RE: Lot 2A & 3A Del Norte Plaza
Grading and Drainage Plan
Engineer's Stamp Date 4-10-2017 (File: C18D042D)

Based upon the information provided in your submittal received 4-10-2017, the above referenced Grading and Drainage Plan is approved for building permit based on the following condition:

ENGINEER'S SEAL	LOT 2 DEL NORTE PLAZA ALBUQUERQUE, NM	DRAWN BY pm
	GRADING AND DRAINAGE PLAN	DATE 4-10-17
		DRAWING 2015064-GR
		SHEET # GR-1
		JOB # 2015064

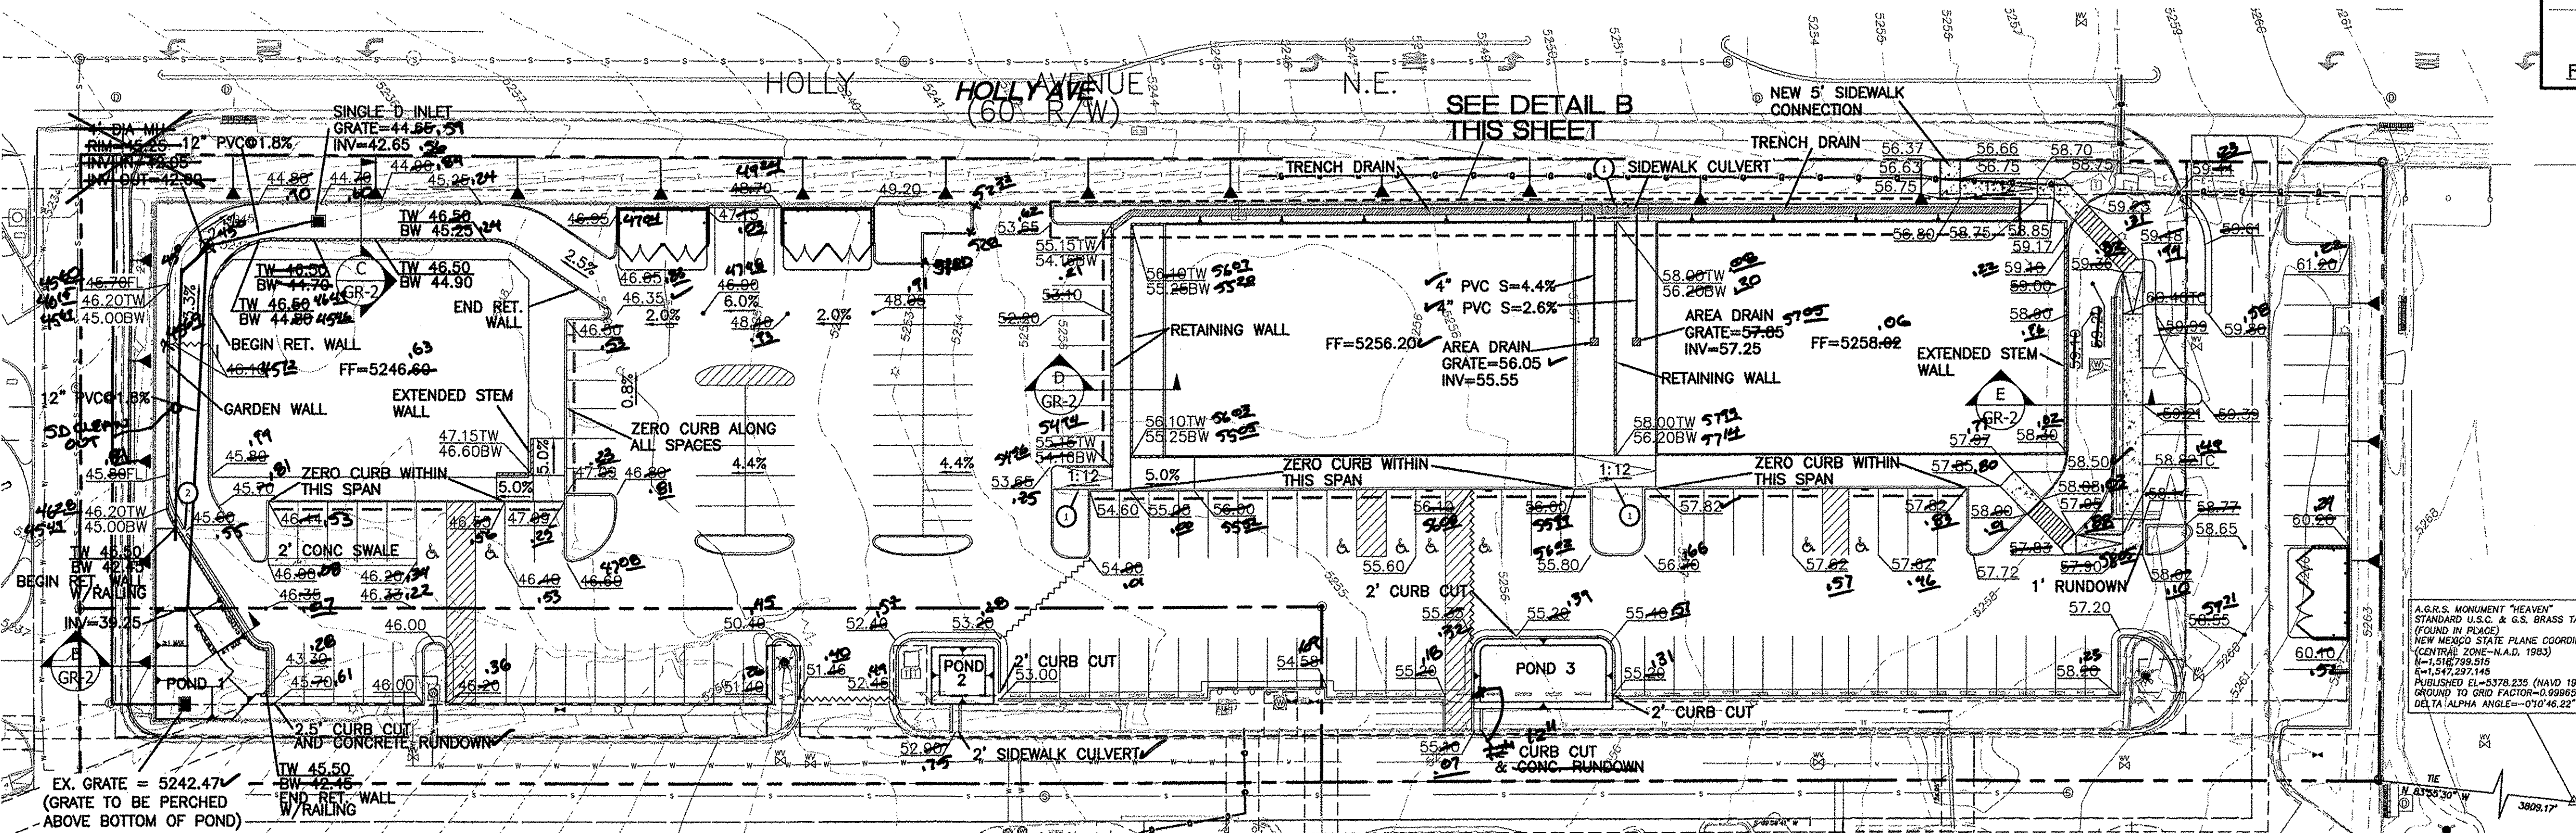
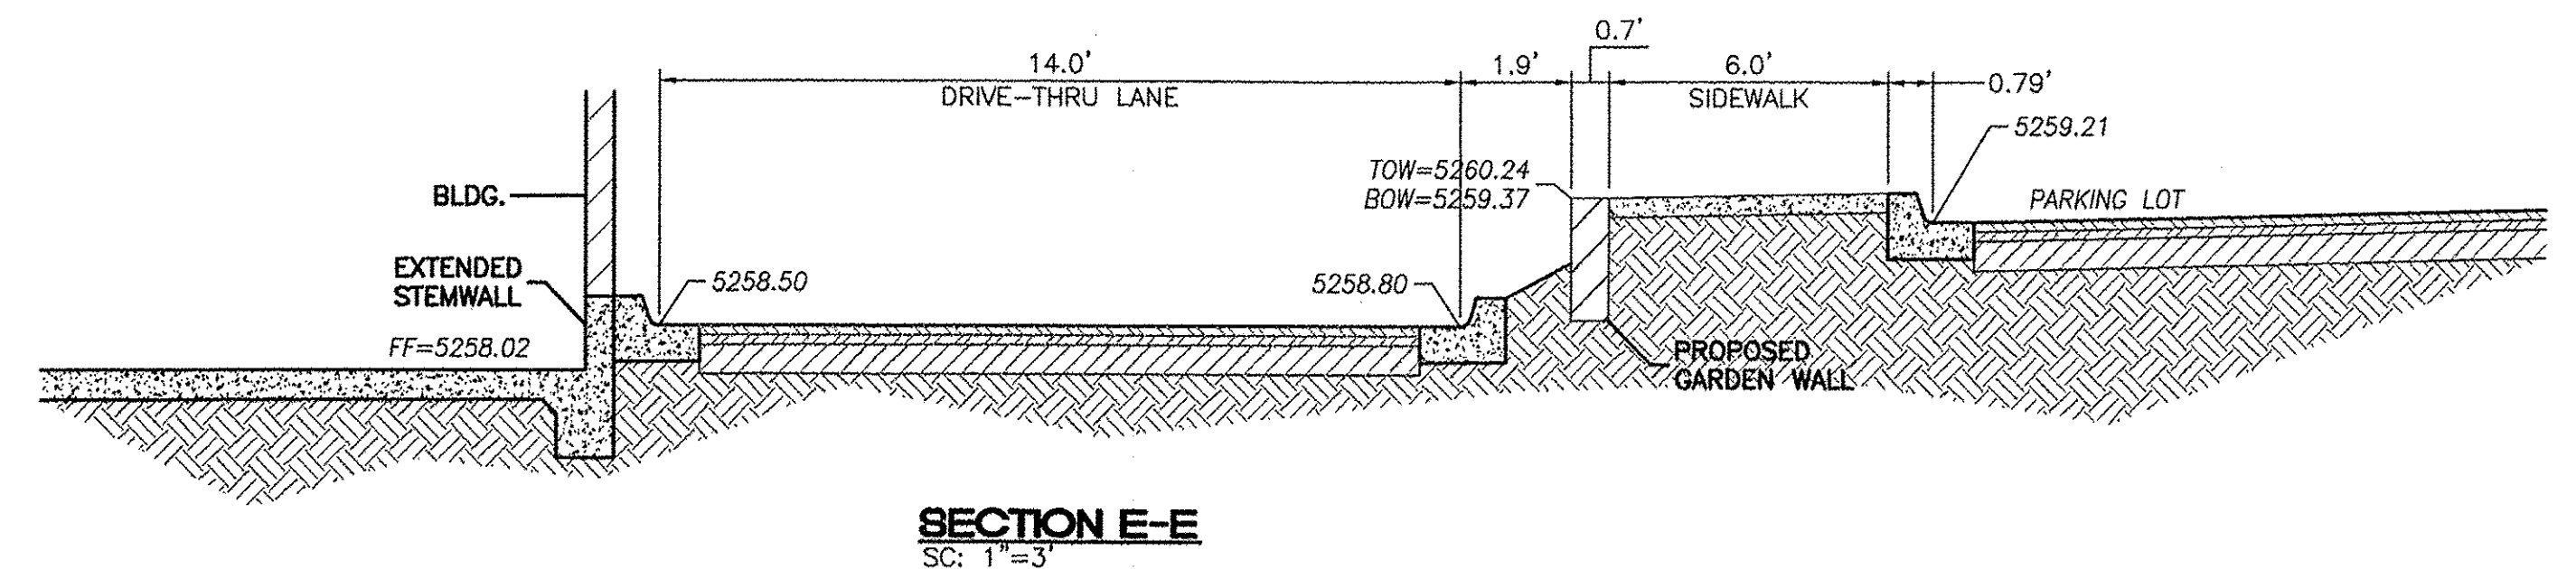
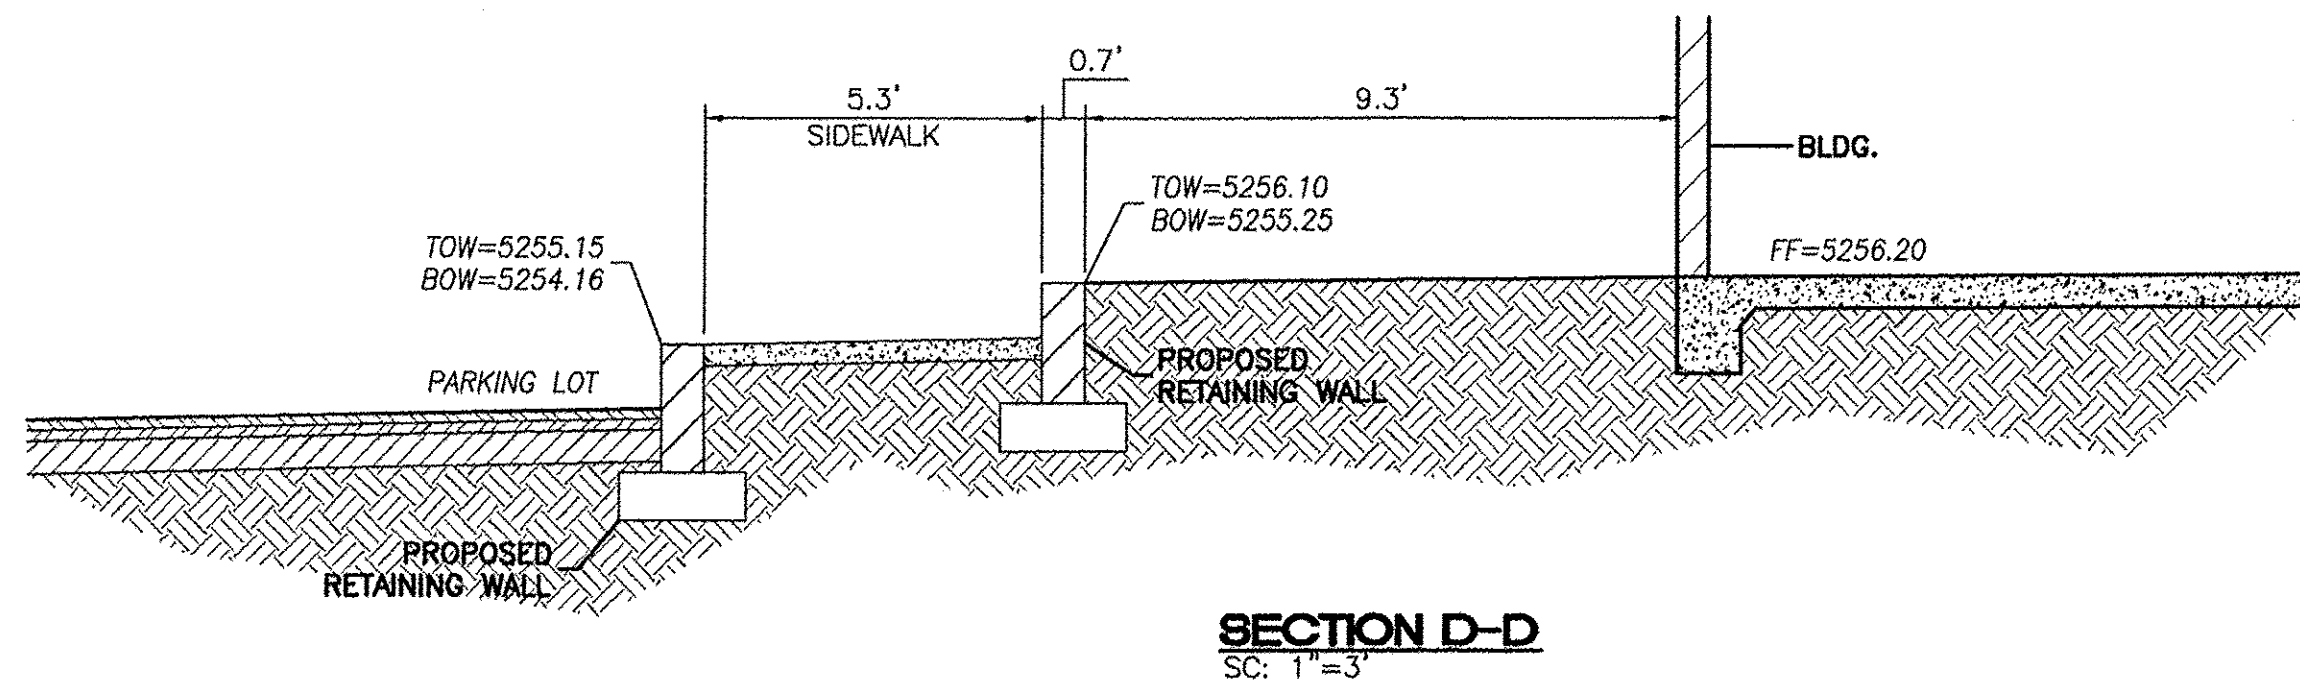
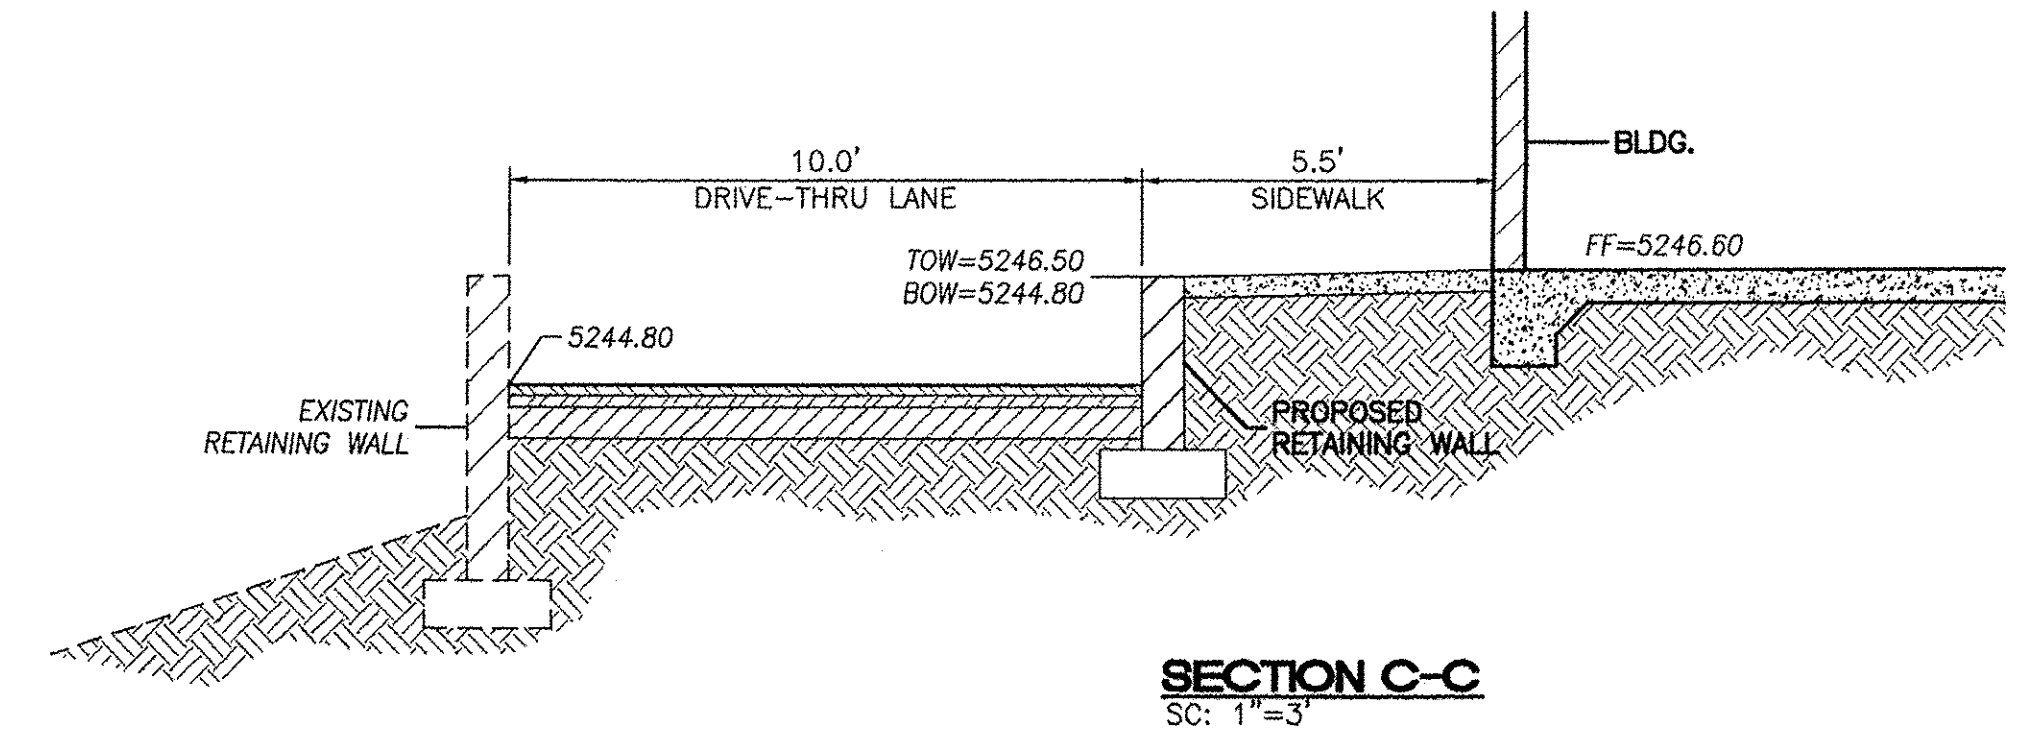
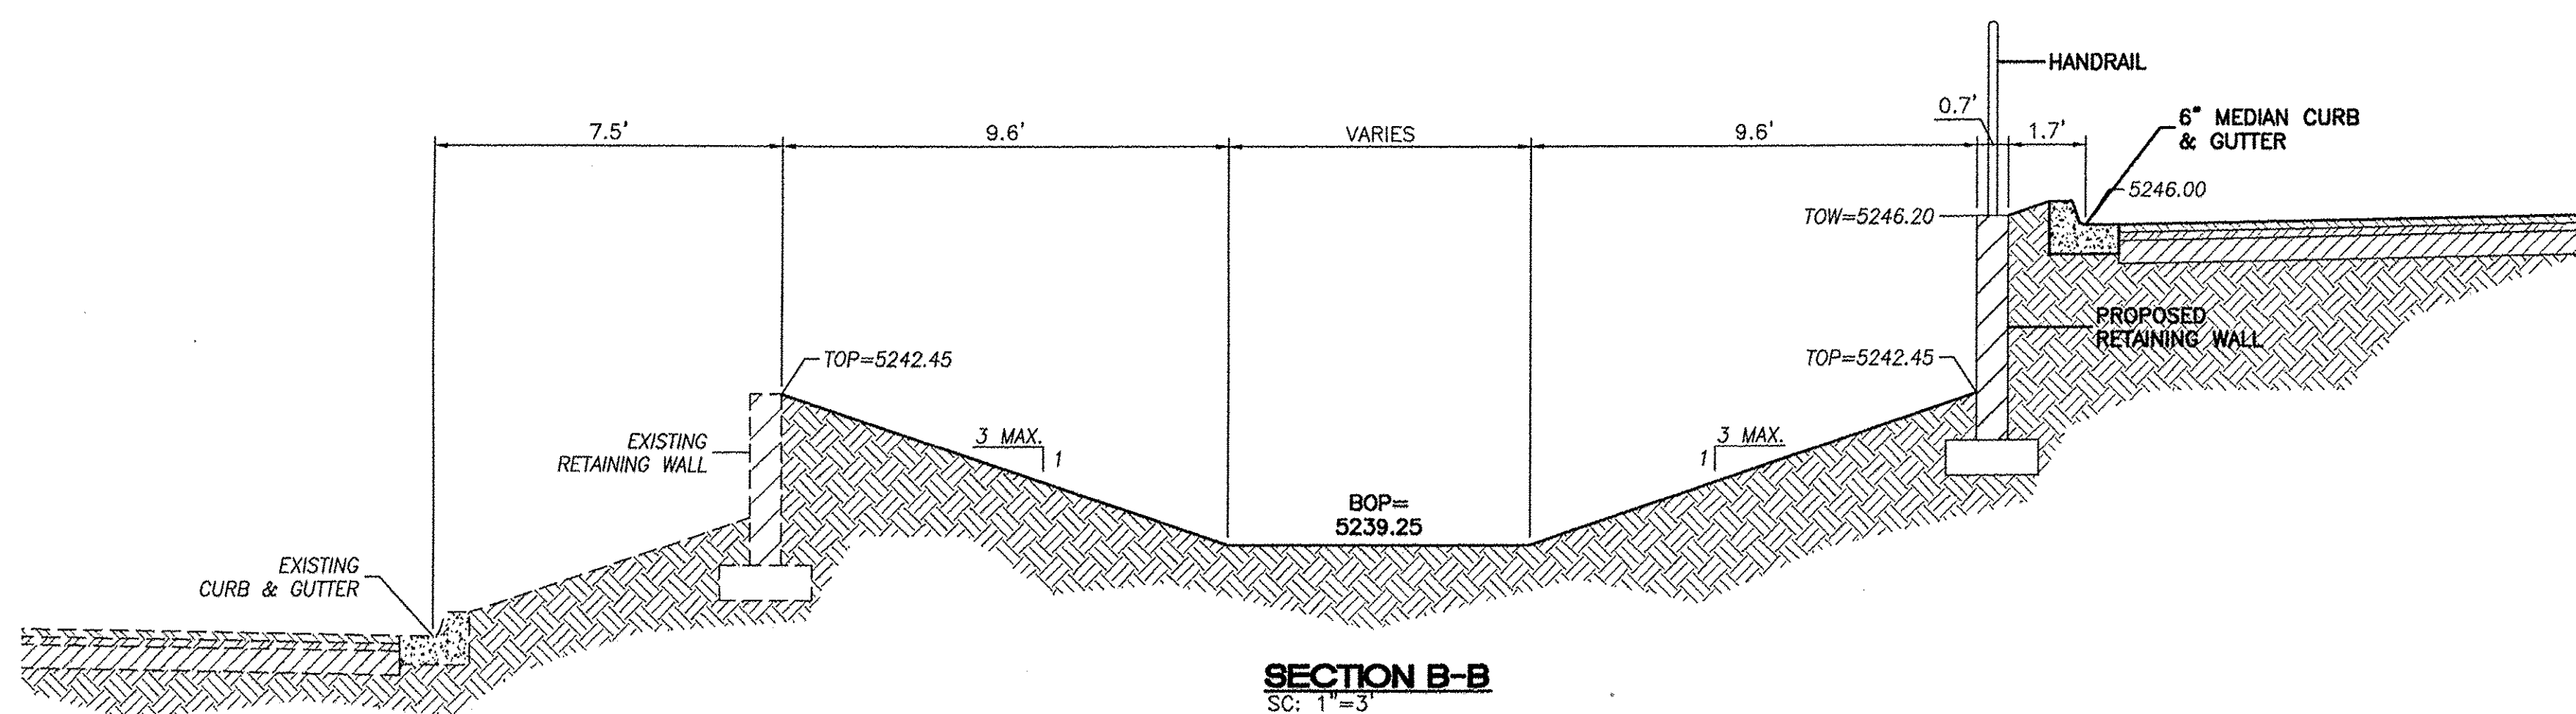
- Trash enclosure if used for restaurants / food services must have drains which would drain to grease traps and then to sanitary sewer system.
